From: Simon Davis [REDACTED]
Sent: 24 March 2017 10:18
To: Developer Services
Subject: The Gatehouse, Lidsey Road, ADC Ref: AL/9/17/DOC, Your Ref: PLAN-017219

Proposal: Application for approval of matters reserved by condition imposed under AL/99/15/PL relating to condition no. 4 (Surface Water Drainage),5(Landscaping) & 9 (Foul Drainage).

Site: The Gatehouse, Lidsey Road, Aldingbourne, PO20 3ST.
AL/9/17/DOC

8590 11 A

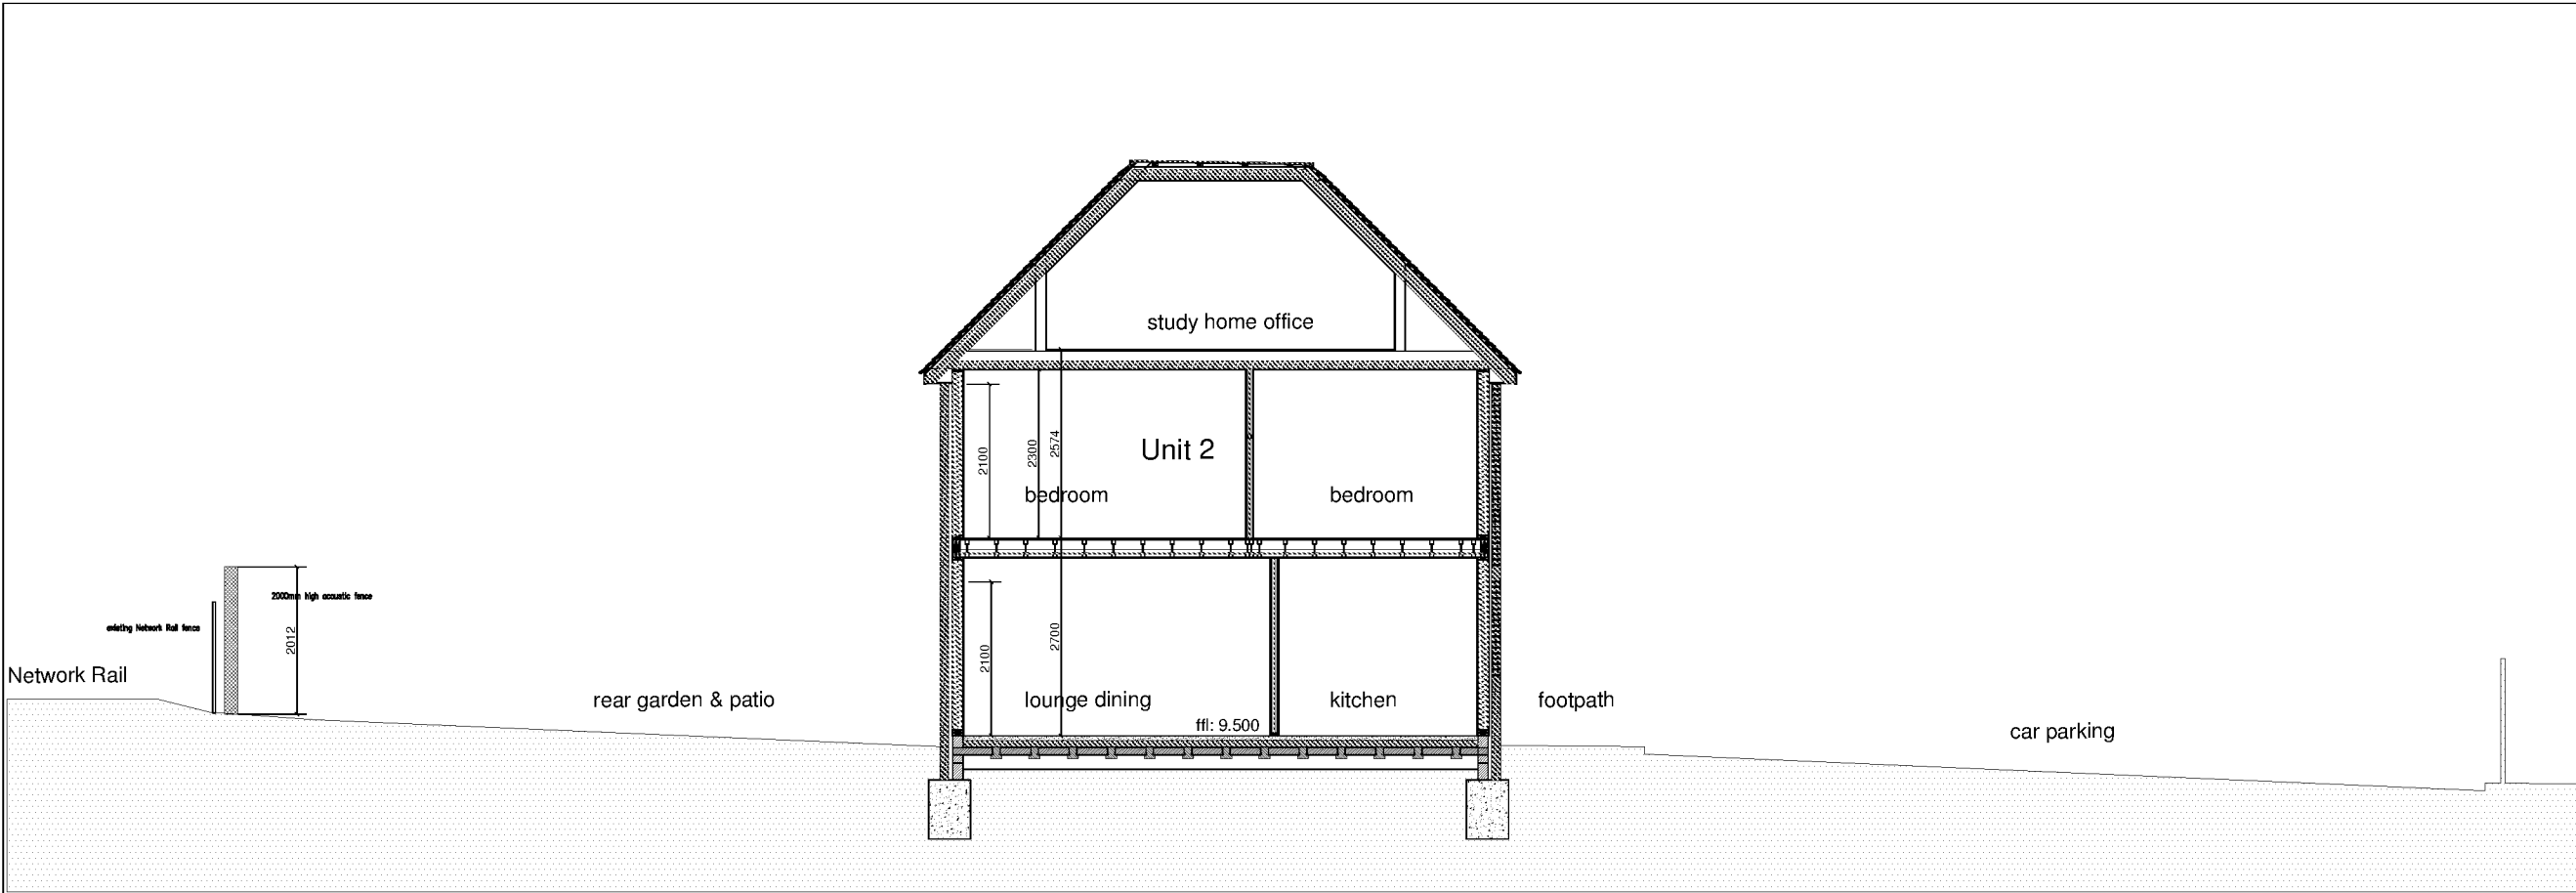
I think I see the problem. We have Drawing 8590-11B on our system which states that:

"Connection pipe that transmits the run-off at the predevelopment rate into the existing sewer. An overflow connection with the top of the permeable pavement sub-base can direct a separate over flow of run-off towards the sewer if the soakaway fills up during an event of greater magnitude than the 1 in 100 year 6 hour + climate change at 30% rainfall event."

I assume then that 8590-10-B should replace 8590-11B? Please confirm.

That is correct, the submitted drawing takes precedence as it is not intended in any way to have the surface water connect into the existing foul system,

project	Residential development The Gatehouse, Lidsey Road. Woodgate		
detail	site layout plan		
drawn	sgr	checked	
date	09-15	status	Const.
a1 scale	1:100	a3 scale	1:200
		8590 10	rev B

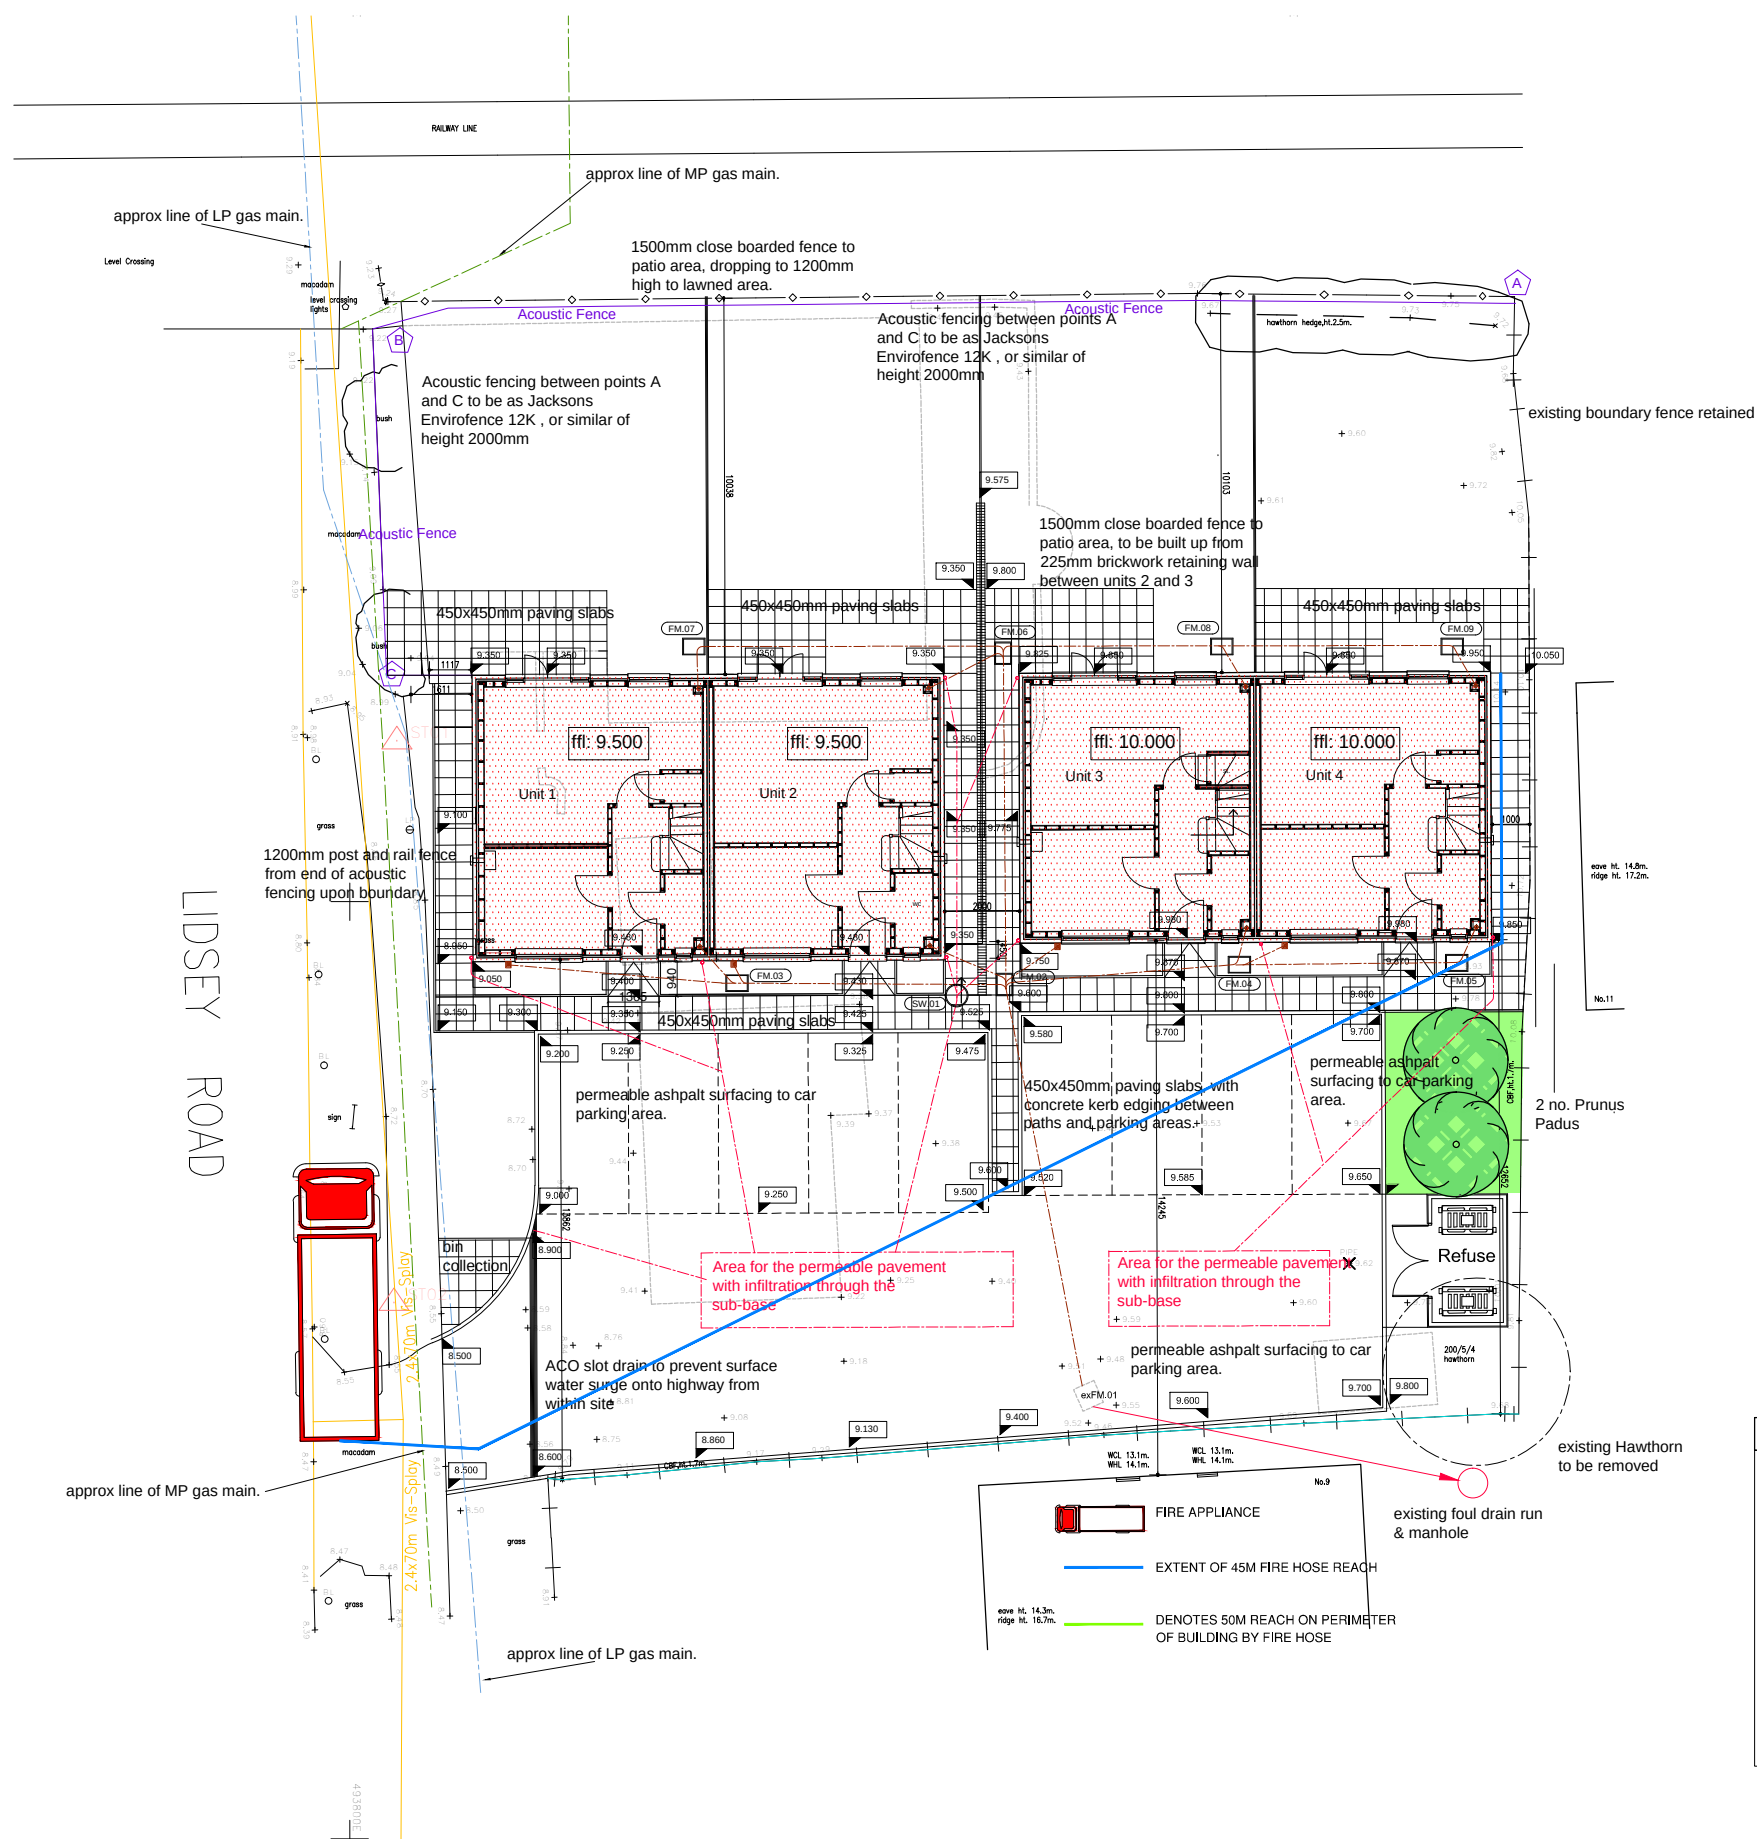
Condition 9 – We attach our drawing number 8590-10B, which had previously been issued, this showing the amendment of the SW to not discharge into the foul drain, so we are somewhat surprised this has not been discharged. It is not the intention to discharge any SW into the foul and the drawing confirms this so we hope this can be discharged immediately.

Southern Water would have no objections to discharge condition 9 relating to foul drainage. The acceptable drainage strategy is as shown on drwg Site Layout Plan 8590 10 Rev B. An approval for the connection to the public foul sewer should be obtained under Section 106 of the Water Industry Act. The design of drainage should ensure that no surface water run off, groundwater or land drainage is to enter public sewers.
